TR010064: Application by National Highways for the M60/M62/M66 Simister Island Interchange Project

The Examining Authority's Written Questions and requests for further information

Issued on 22 October 2024

Reproduced by permission of Ordnance Survey on behalf of HMSO. © Crown copyright and database right 2024. All rights reserved. Ordnance Survey Licence number 100030649.

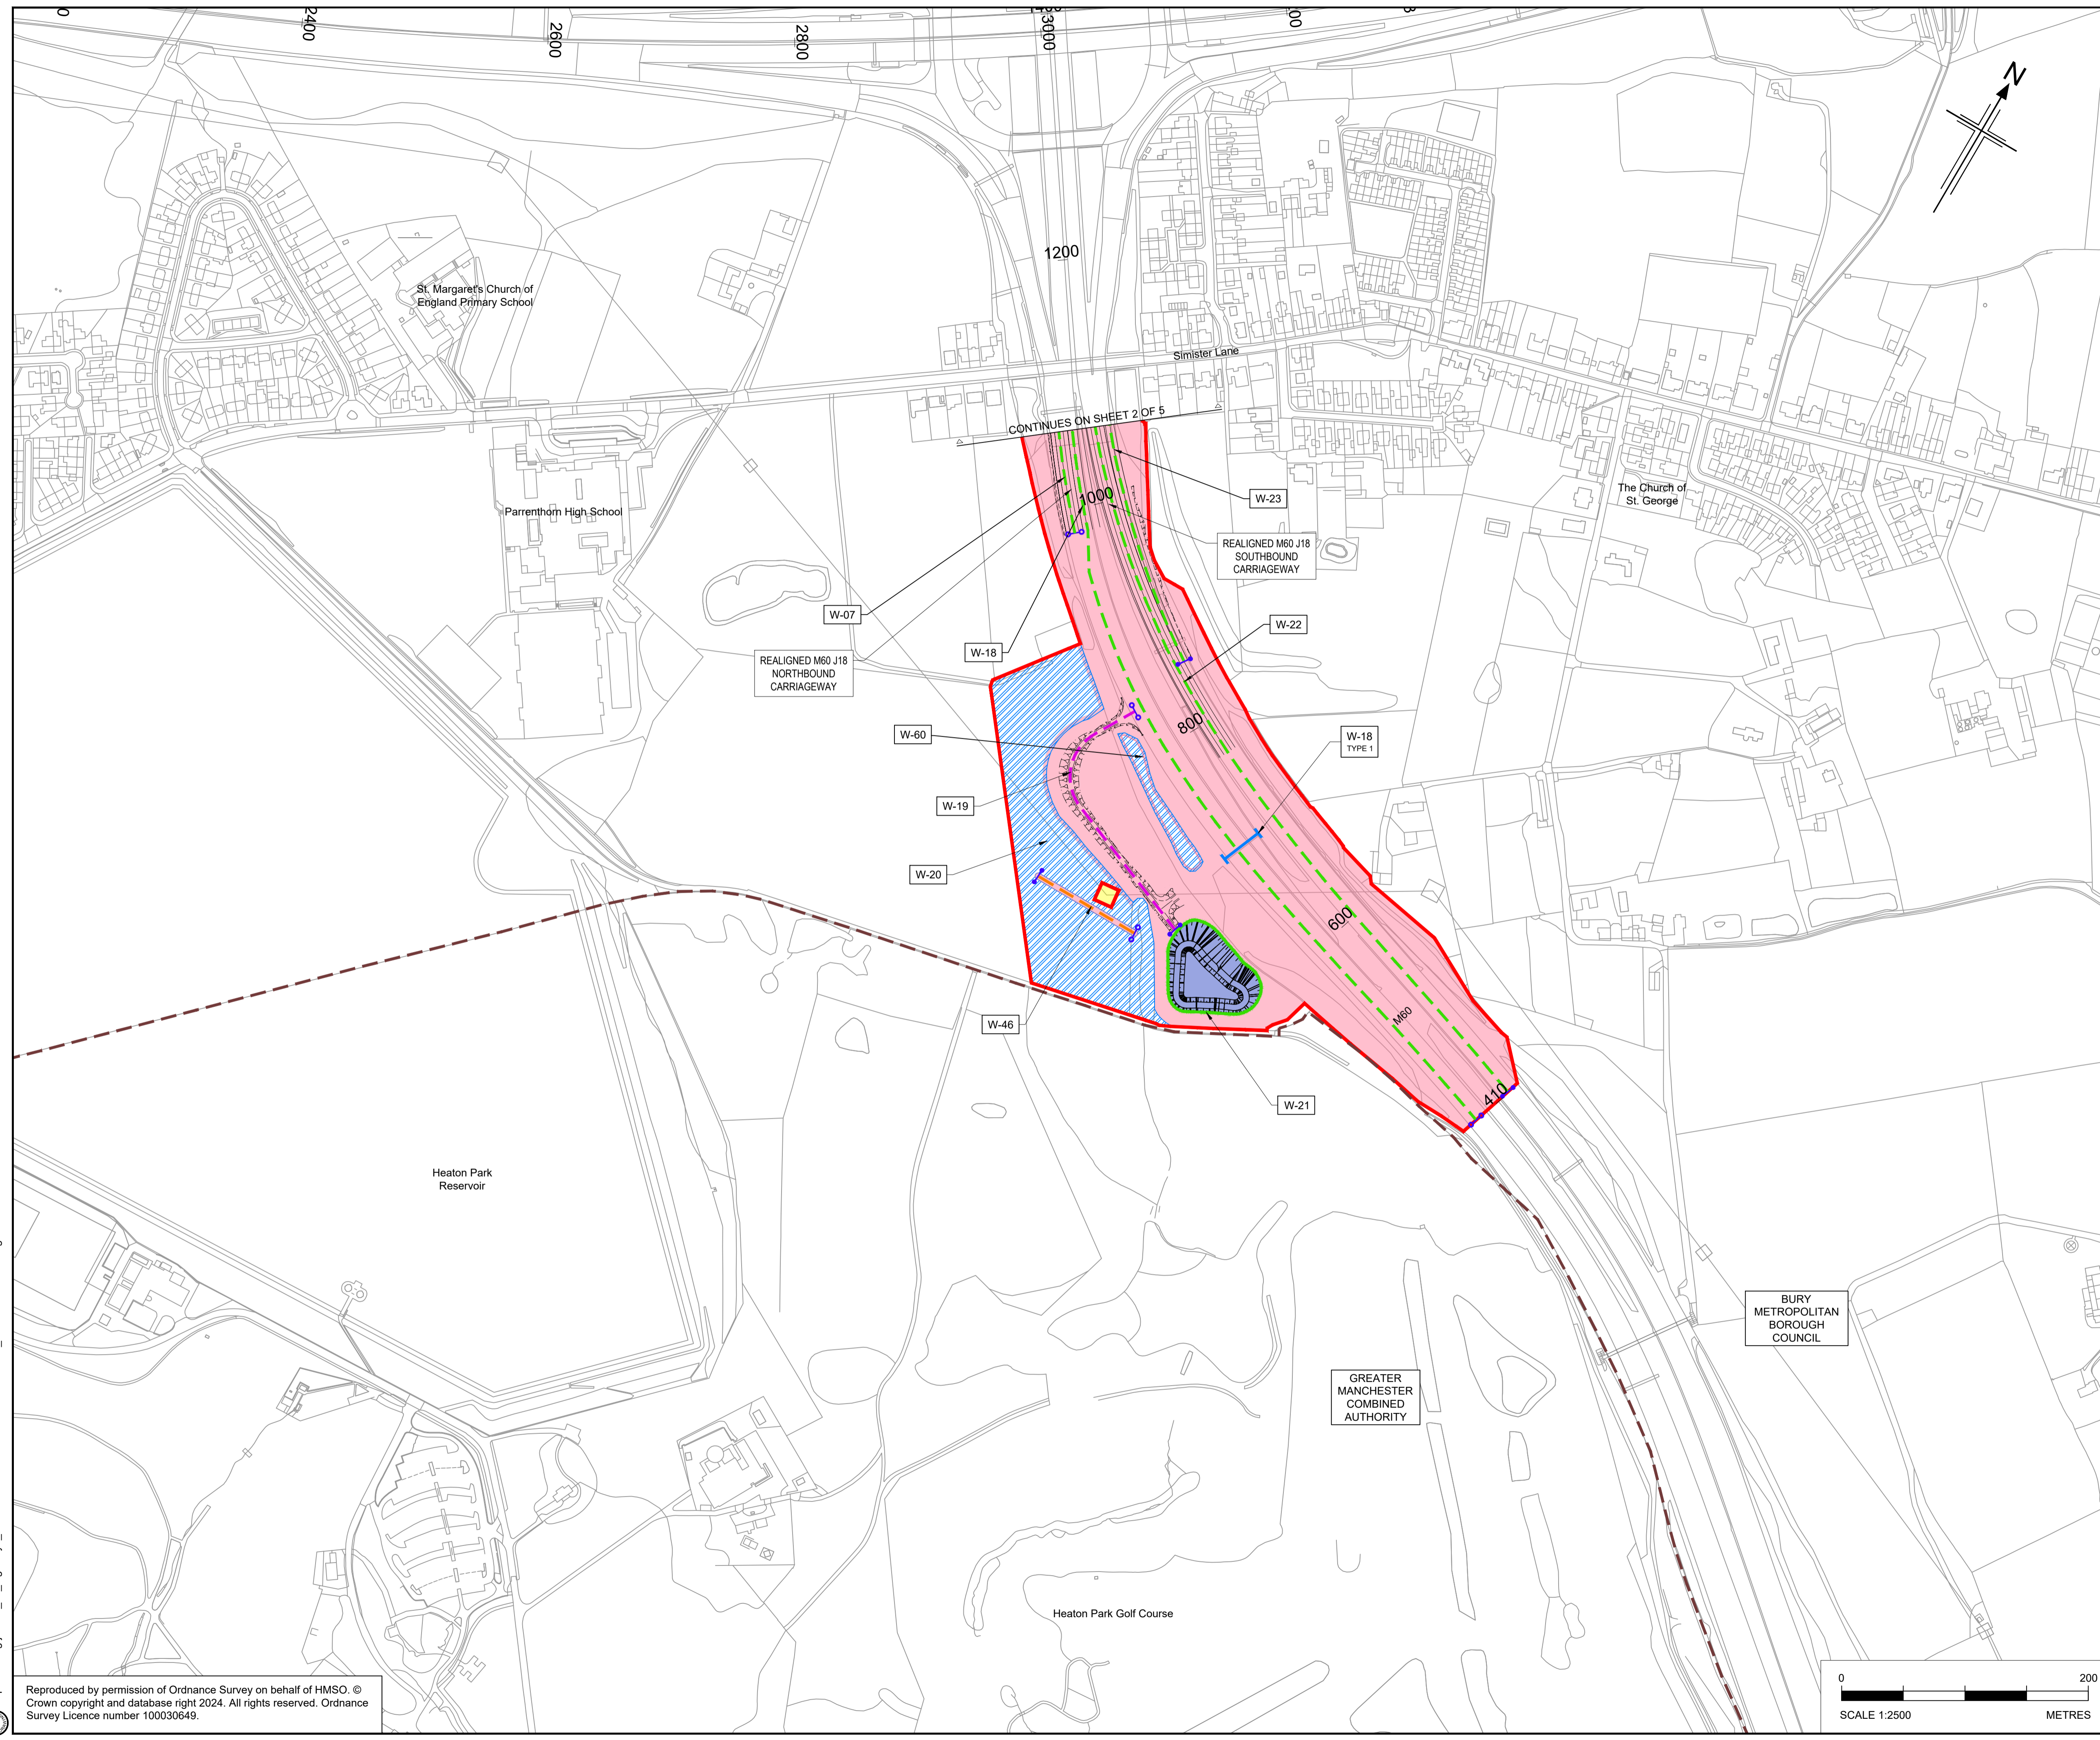
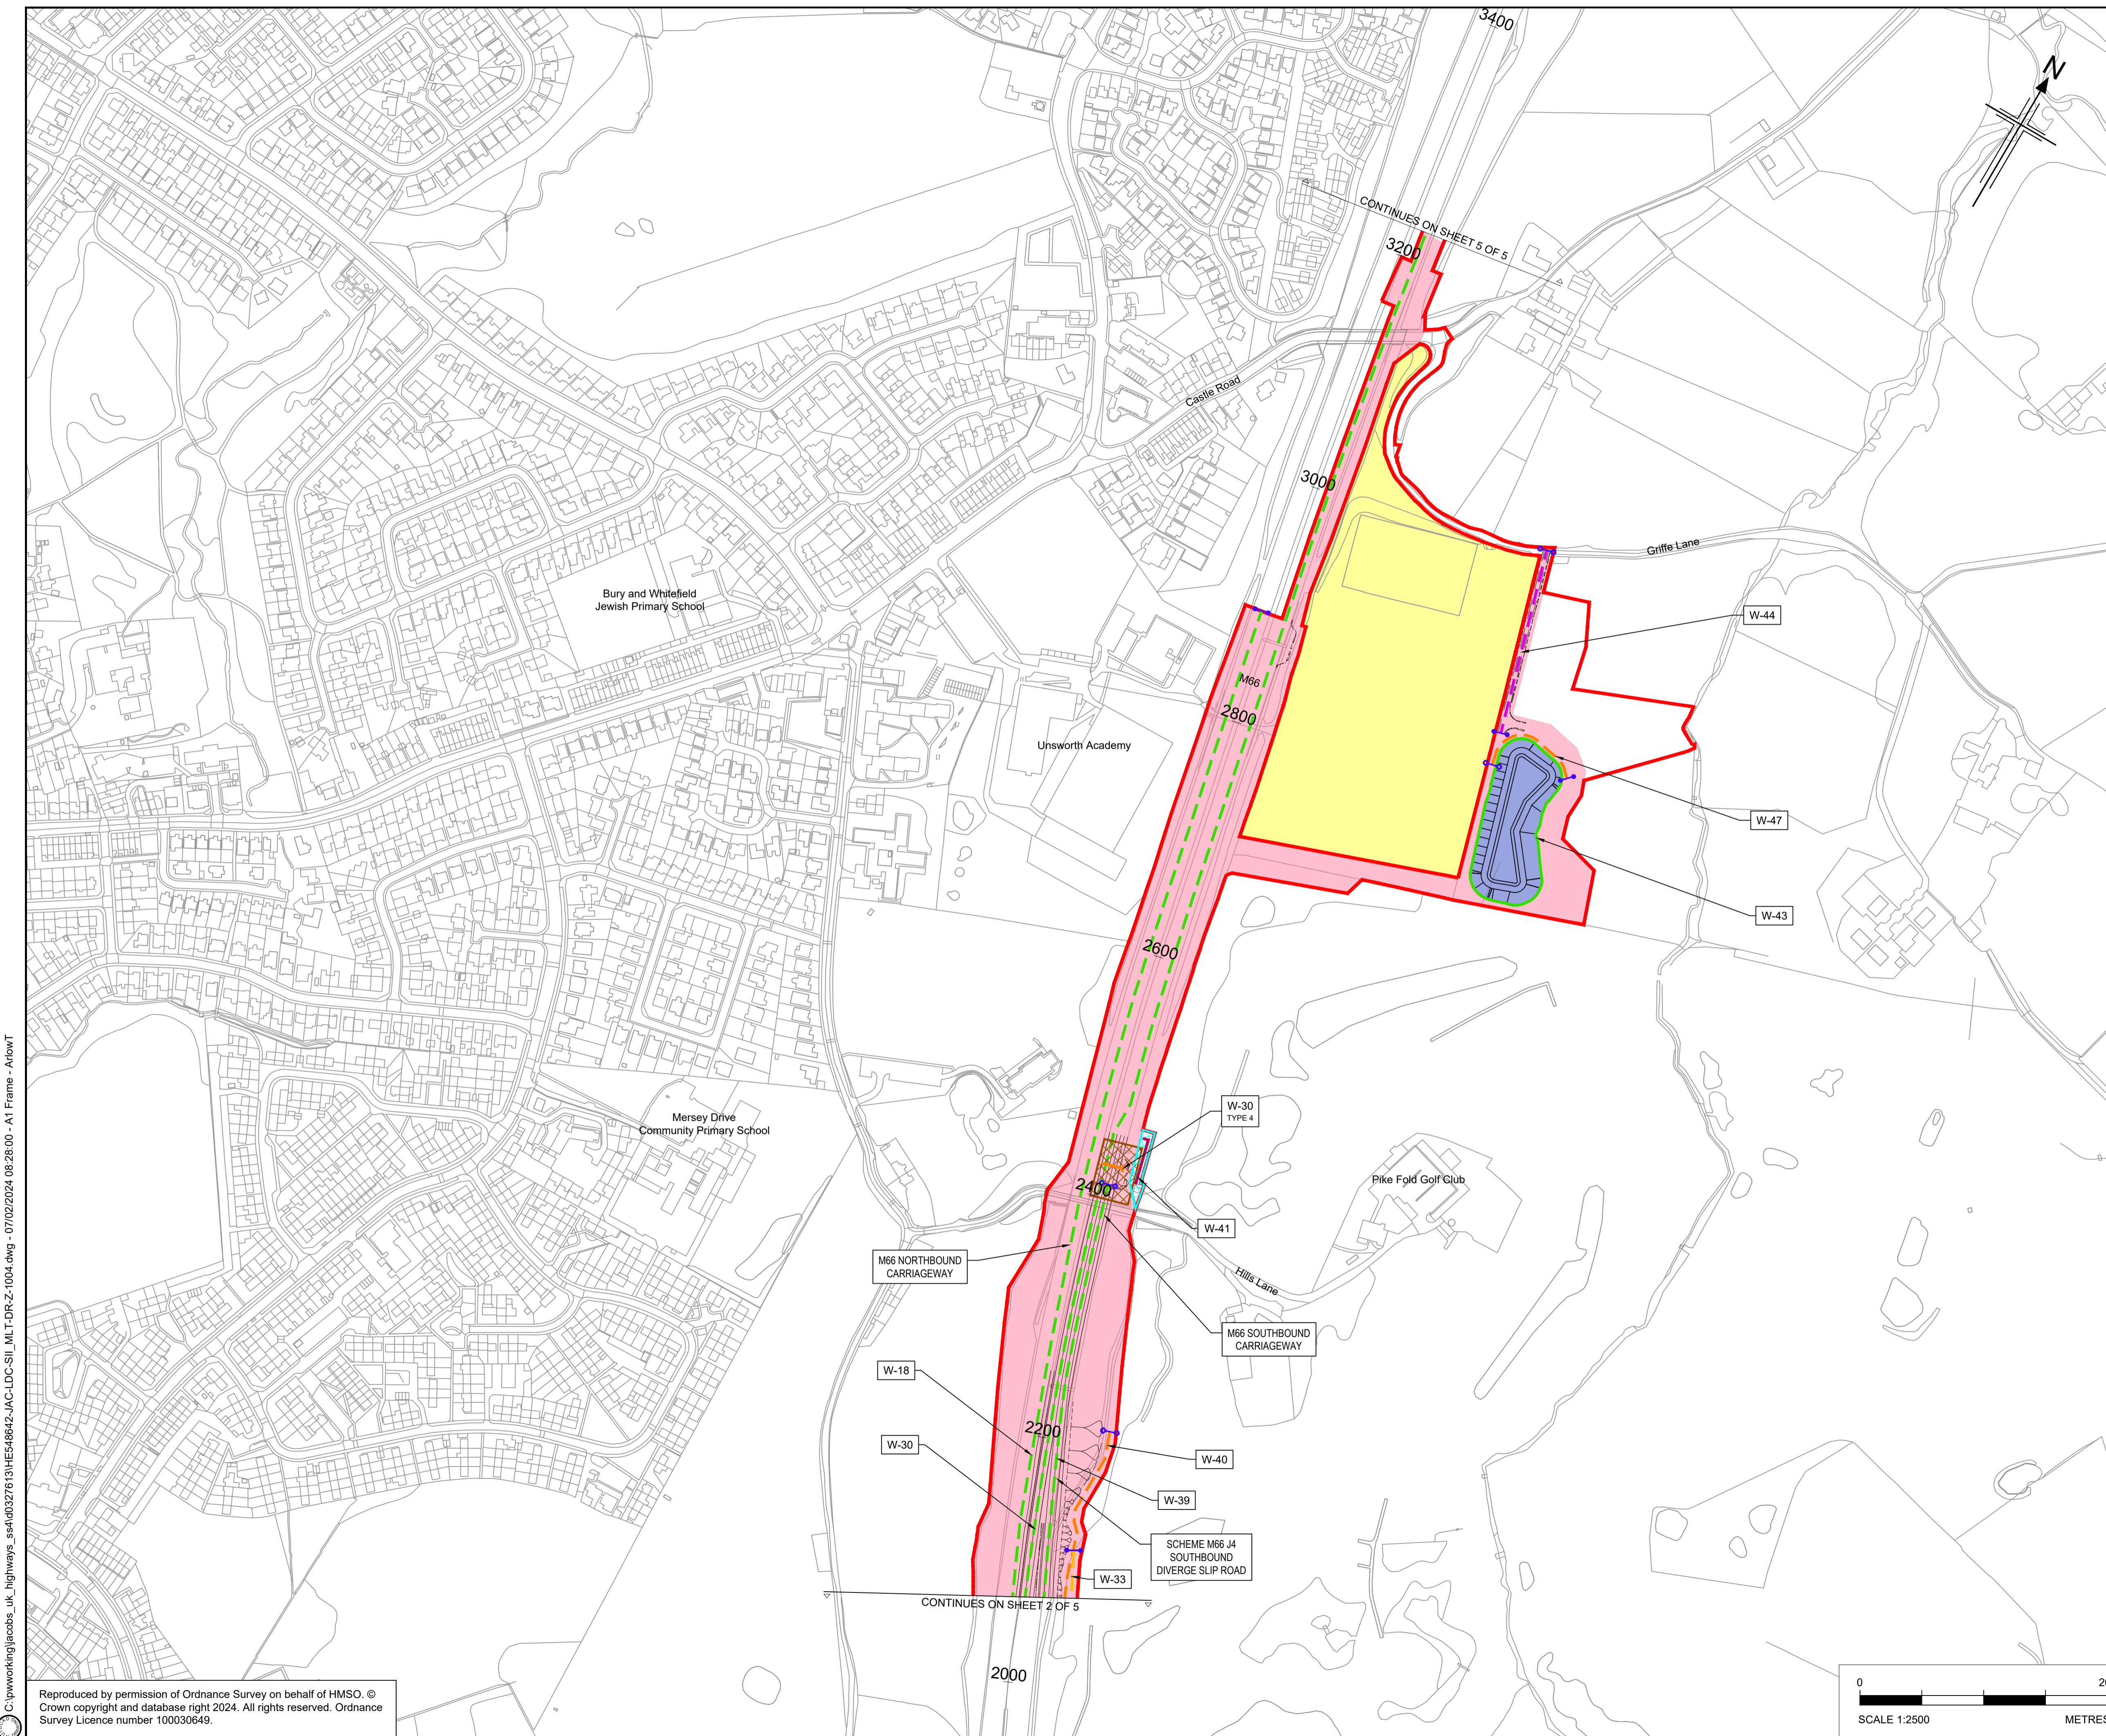
ExQ1	Question to:	Question
CA.1.9	Applicant	<p>Works Plans</p> <p>The Works Plans [AS-006] contain areas of white land, which are unexplained in the legend. The ExA consider Works Plans should be fully explanatory and indicate all land and its intended works. Amend the Works Plans, and fully annotate each area of land with a Work No.</p>
CA.1.10	Applicant	<p>Land Plans</p> <p>The Applicant's response in [REP2-007] to D1 submission [REP1-033] states "<i>The Applicant confirms that, in respect of plot 1/33b, no temporary land take is required, and the Applicant is seeking permanent Rights for access in connection with future maintenance of the Scheme only</i>". The Land Plans [AS-005] shows plot 1/33b as blue which is described as "<i>Land to be used temporarily and Rights to be acquired permanently</i>". Are there any other plots, which are shown as blue, where it is not intended that they will be used temporarily and only Rights are sought to be acquired? Consider how the plots could be coloured on the Land Plans to clarify where only Rights over land are being sought and provide revised Land Plans accordingly.</p>
